CITY OF ALBUQUERQUE

August 19, 2024

RE: 2103 Los Luceros Rd. NW
Grading and Drainage Plan
Engineer's Stamp Date: 6/17/24
Hydrology File: H12D025

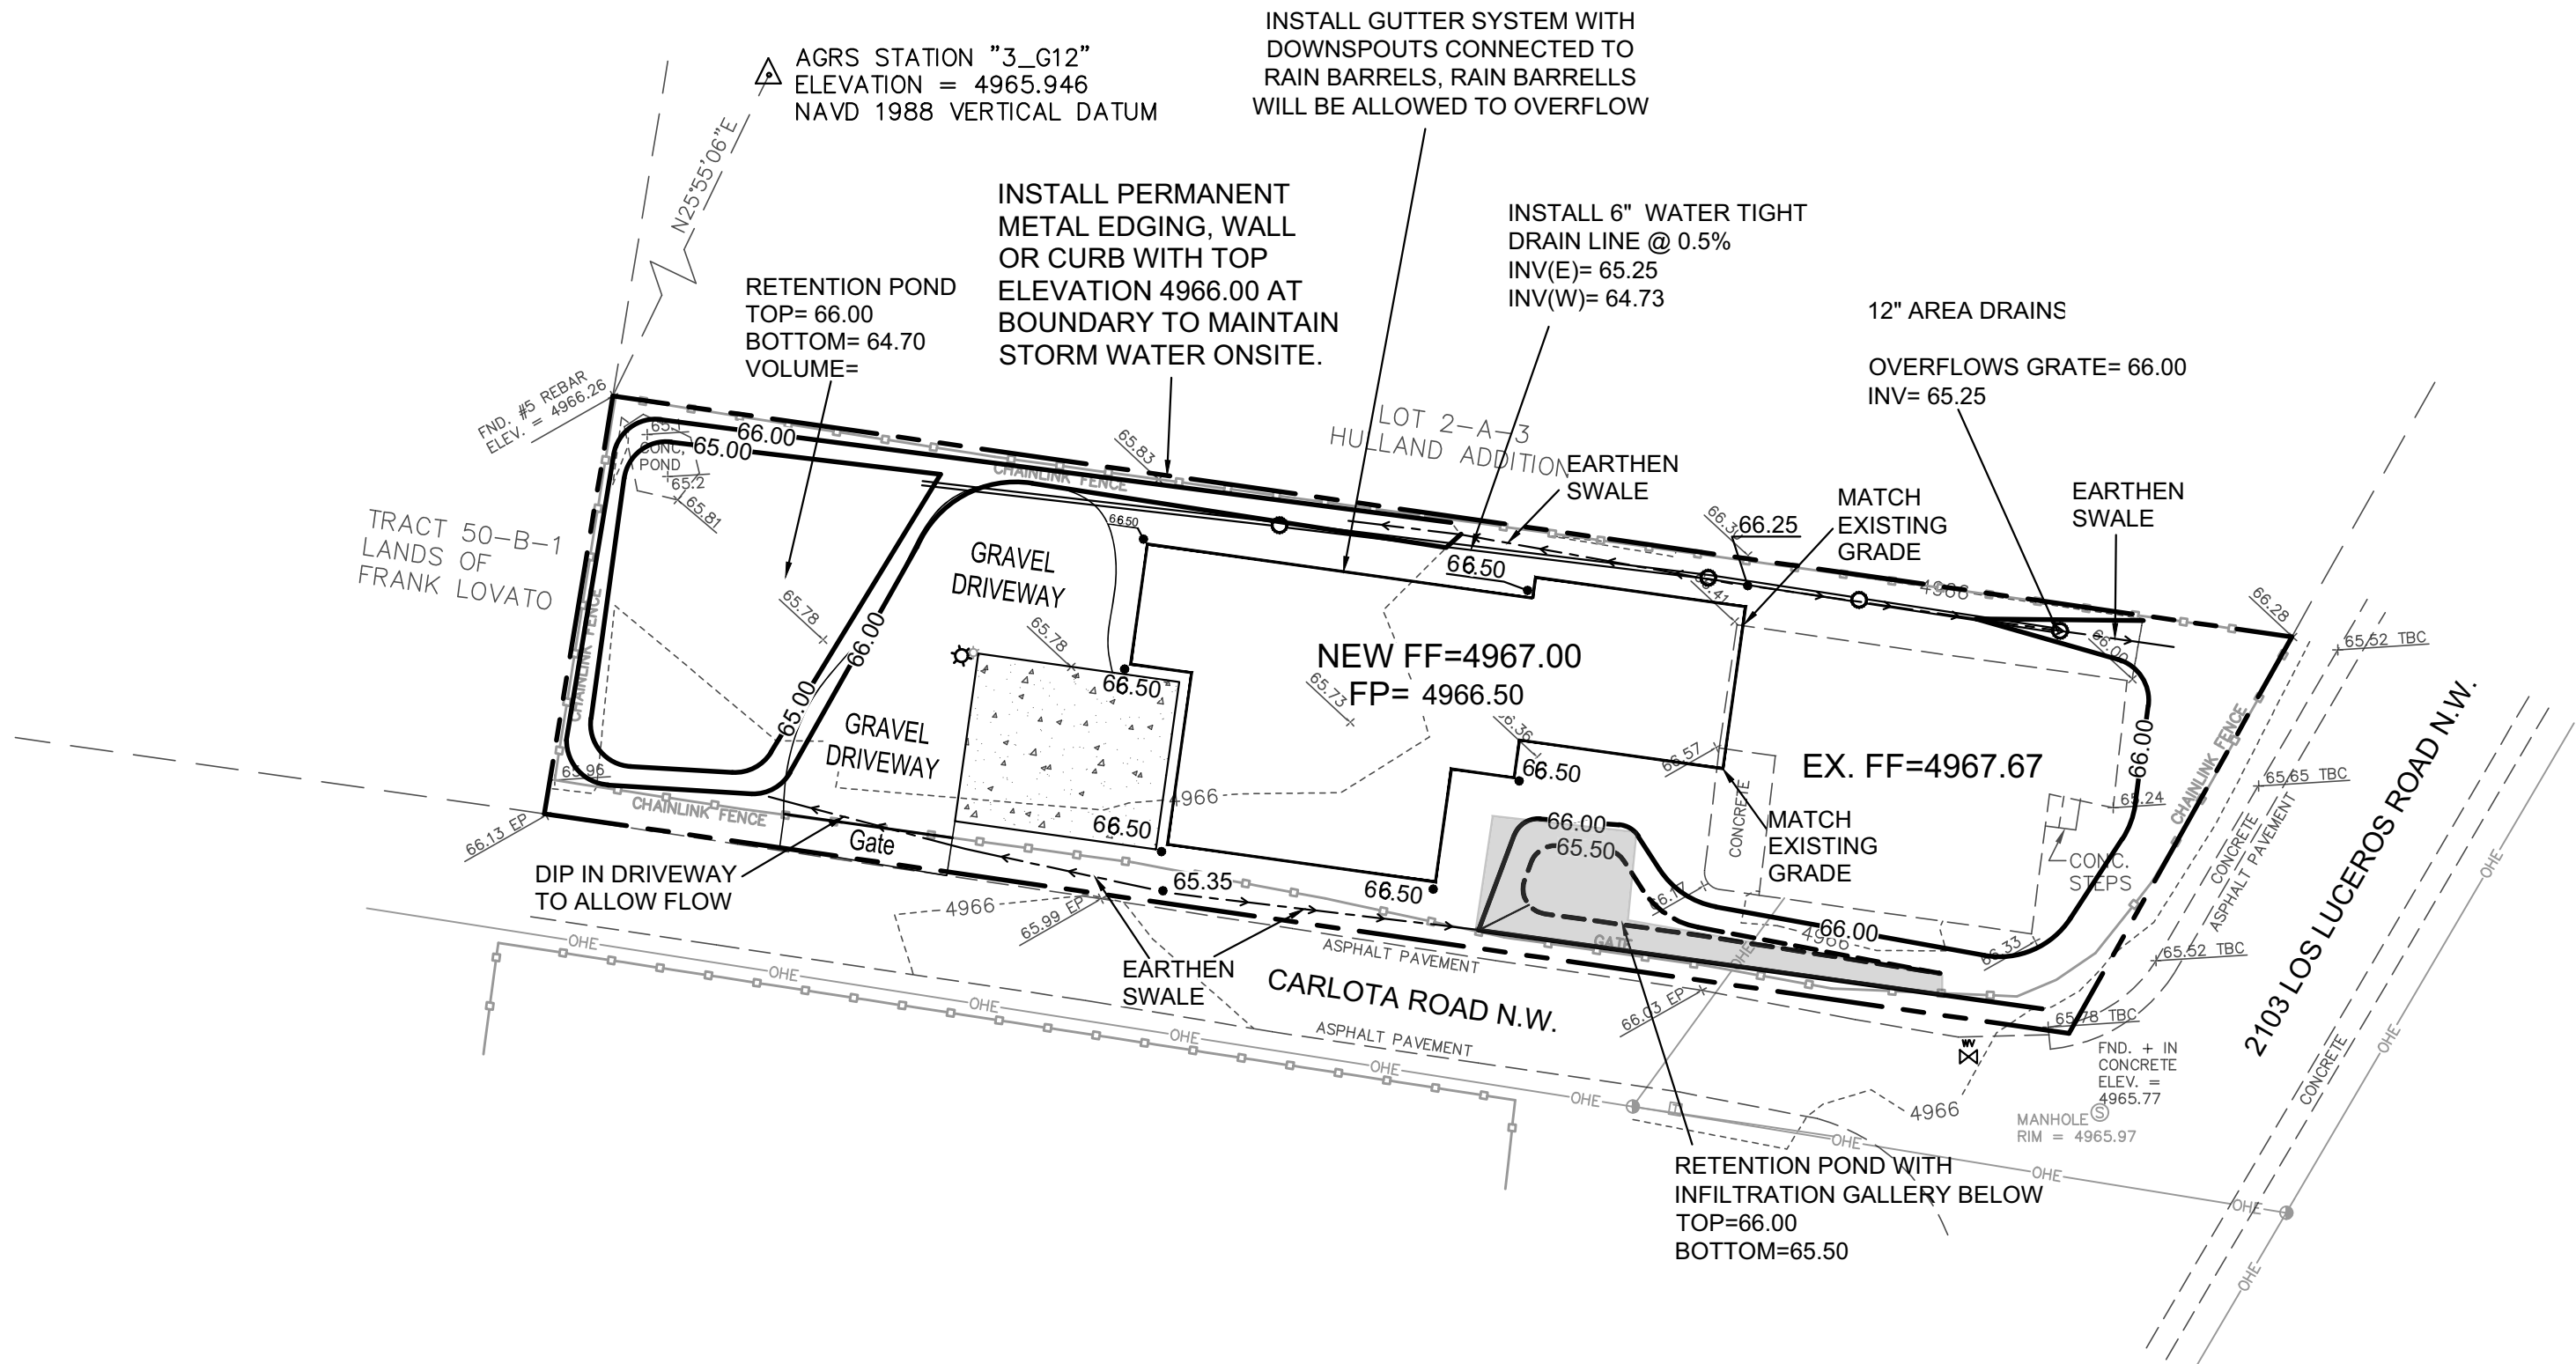
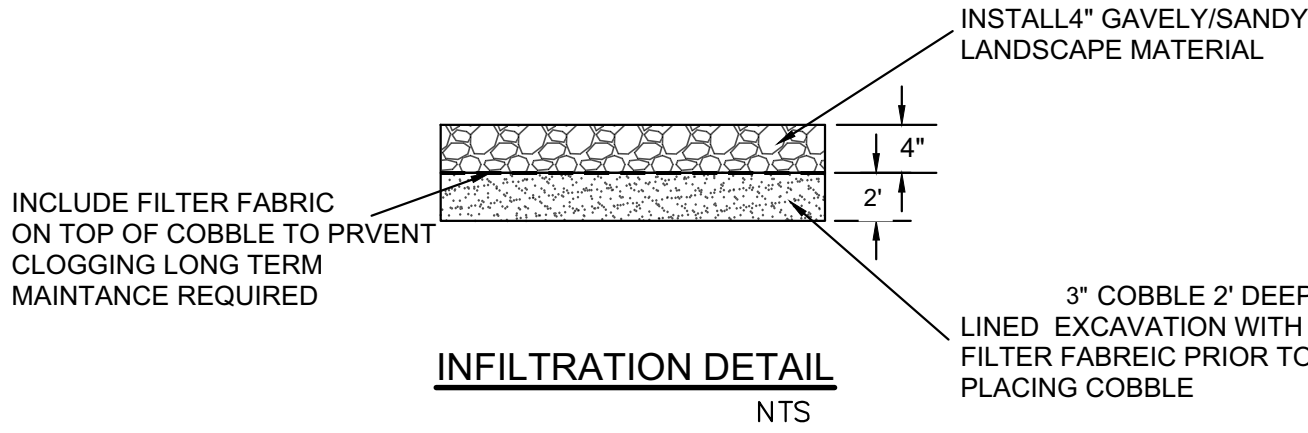
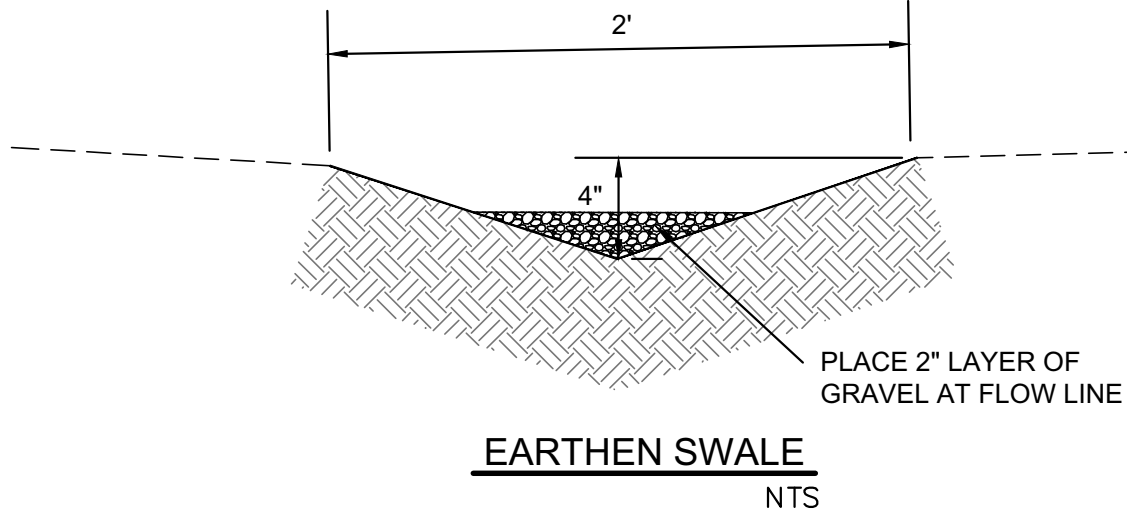
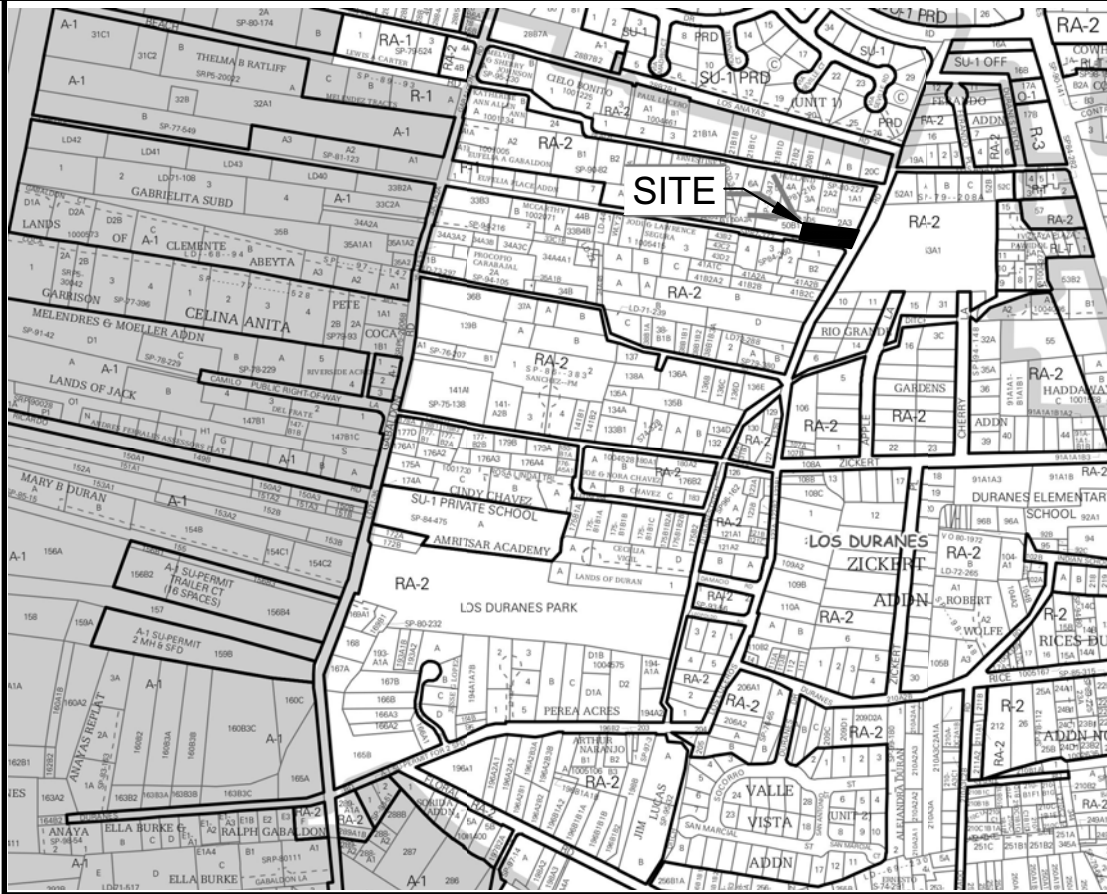
1. For review and recording purposes, the font size of the Weighted E Method information block should be at least the same font size as the EROSION CONTROL NOTES.

2. The narrative information below the Weighted E Method calculations appears to be cut off and should be reviewed for accuracy and clarity. The revised resubmittal should show the corrected and appropriate information.

3. The narrative states "The ponds will overflow to the adjacent lots and ultimately to the street in the event of a storm . . ." is not acceptable and the entire narrative should be reviewed and revised for accuracy, AND state that no storm water will adversely impact adjacent lots.

4. The scale as shown should be revised to 1" = 20' in a subsequent resubmittal.
5. Please provide the SWQV calculations on the plan. Provide management onsite for the Stormwater Quality Volume (SWQV) in accordance with the new drainage ordinance, § 14-5-2-6 (H). Please follow the DPM Article 6-12 Stormwater Quality and Low-Impact Development for the sizing calculations. To calculate the required SWQV, multiply the impervious area draining to the BMP by 0.26 inches for redevelopment sites. The calculations of both the required and the provided volume of each BMP must be shown on the Grading and Drainage Plan.
